Re: Littleton Wind Farm - Proposed 11-turbine development, Co. Tipperary - Case PAX92.324370

Submission / Observation Objecting to Littleton Wind Farm**PAX92.324370**

Addendum to Appendix C of Appendix 8.1 - Drained and Undrained FoS Results for PRA B1 and B2

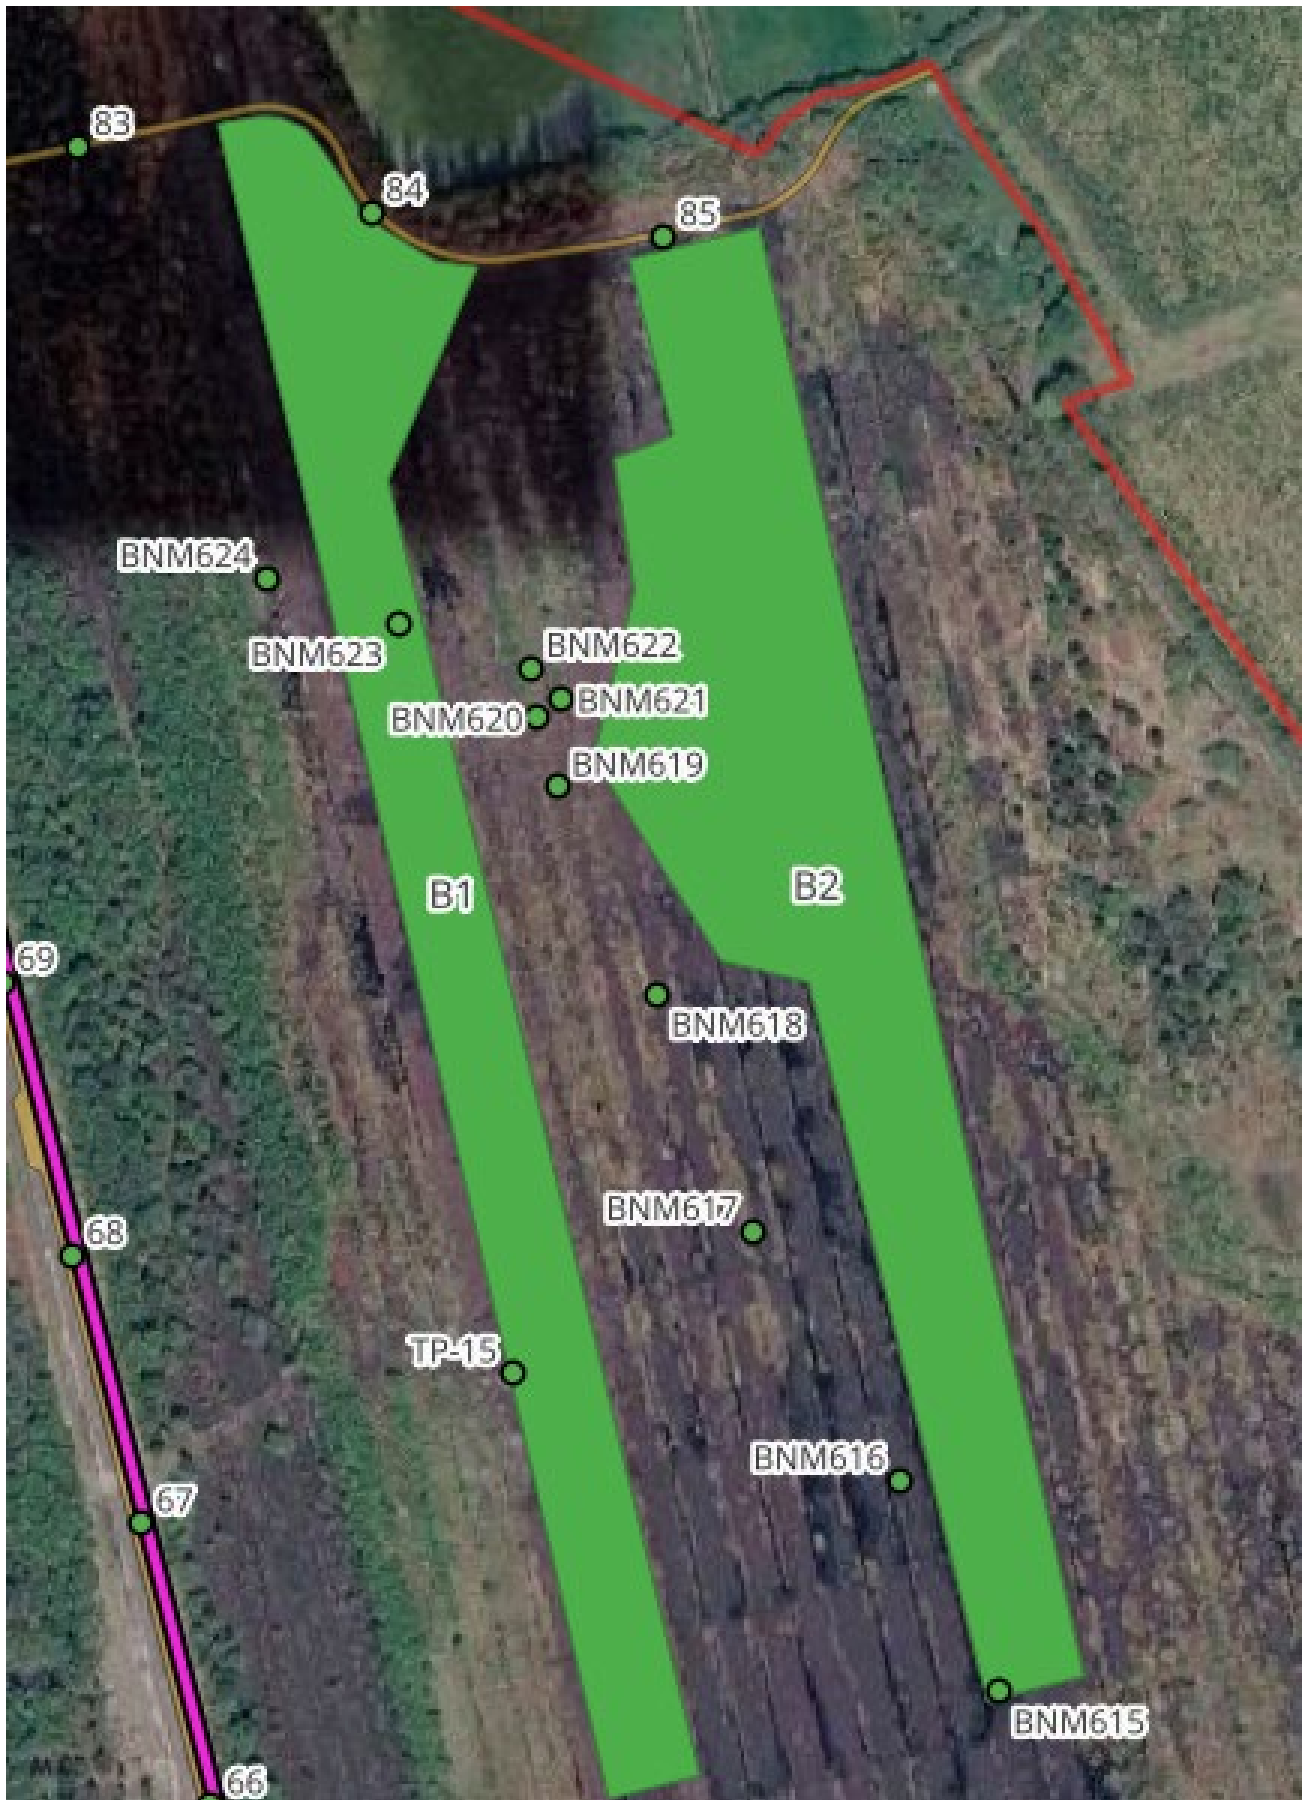
There is a separate concern regarding Peat Repository Areas B1 and B2. The Factor of Safety tables record “No Information” for both areas under drained and undrained conditions, yet the subsequent risk assessment assigns them a Negligible risk classification. This does not prove that either repository is unstable, but it is unclear what quantitative or site-specific basis supports a Negligible classification where the principal stability tables provide no result. (Appendix 8.1.)
